5 September 2016

Re: Exhibition of State Significant Development Application for Staged Commercial Precinct, West Hoxton (SSD 6407)

Council has considered the Response to Submissions document provided, which addressed Council's submission of 11 December 2015, and its amended submission dated 5 February 2016. Council makes comments as follows in relation to the responses provided:

Figure 6.1. Upstream Catchments & Proposed Management

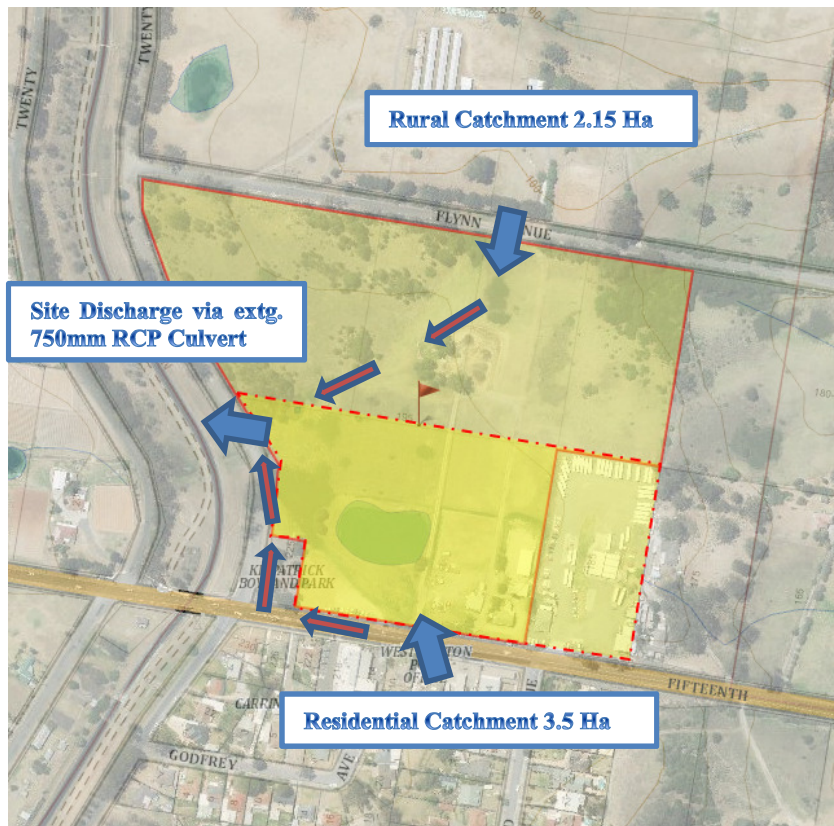
- a) There is an overland flow path across the site conveying stormwater flows to an existing 750mm culvert on the western boundary from the residential development located to the south of Fifteenth Avenue. It has been proposed to divert the stormwater flow around the development site via a stormwater pipe along Fifteenth Avenue up to the intersection with Twenty Seventh Avenue and then via an open channel up to the 750mm culvert.

The proposed pipe should be designed to convey flows for the full length of the diversion and should have capacity to convey the 100year ARI flow from the catchment. An open channel for conveying stormwater flows along the road section is not acceptable.

It is recommended that the open channel sections proposed along Twenty Seventh Avenue be piped with appropriate blockage factor. It is also recommended that the hydraulic/hydrologic analysis of proposed stormwater pits/pipes, along with the necessary plans and a design report, be provided for Council's approval, prior to the issue of a construction certificate.

CONCEPT CIVIL WORKS PLAN
SCALE 1:500

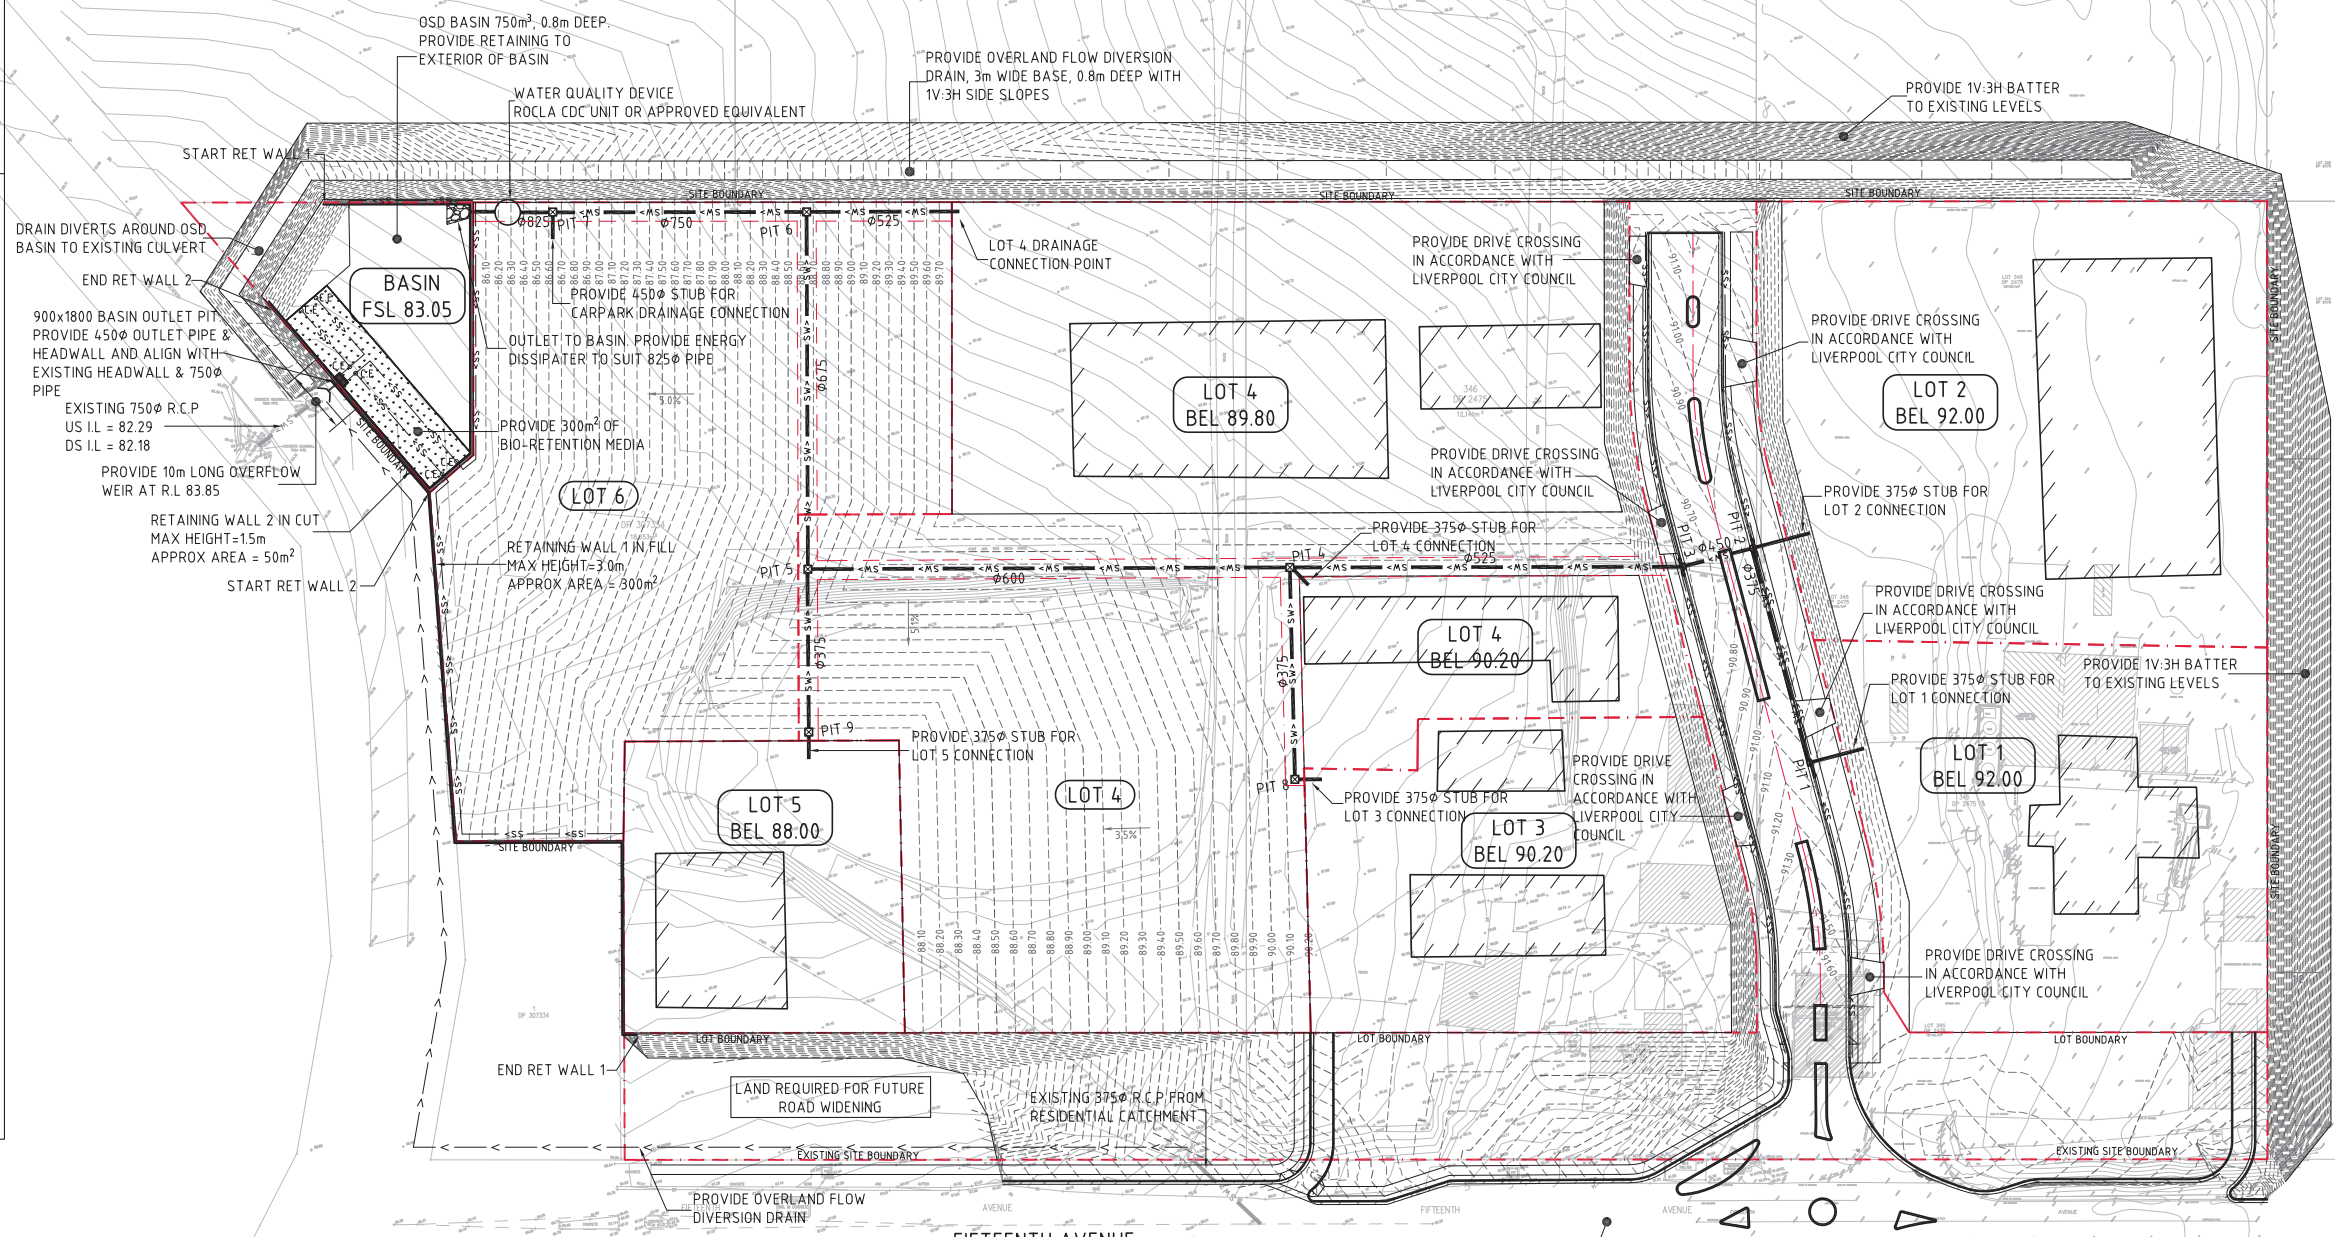
- b) Review the capacity of the existing 750mm culvert under Twenty Seventh Avenue to ensure that it has adequate capacity to discharge flows safely from the development and external catchments.
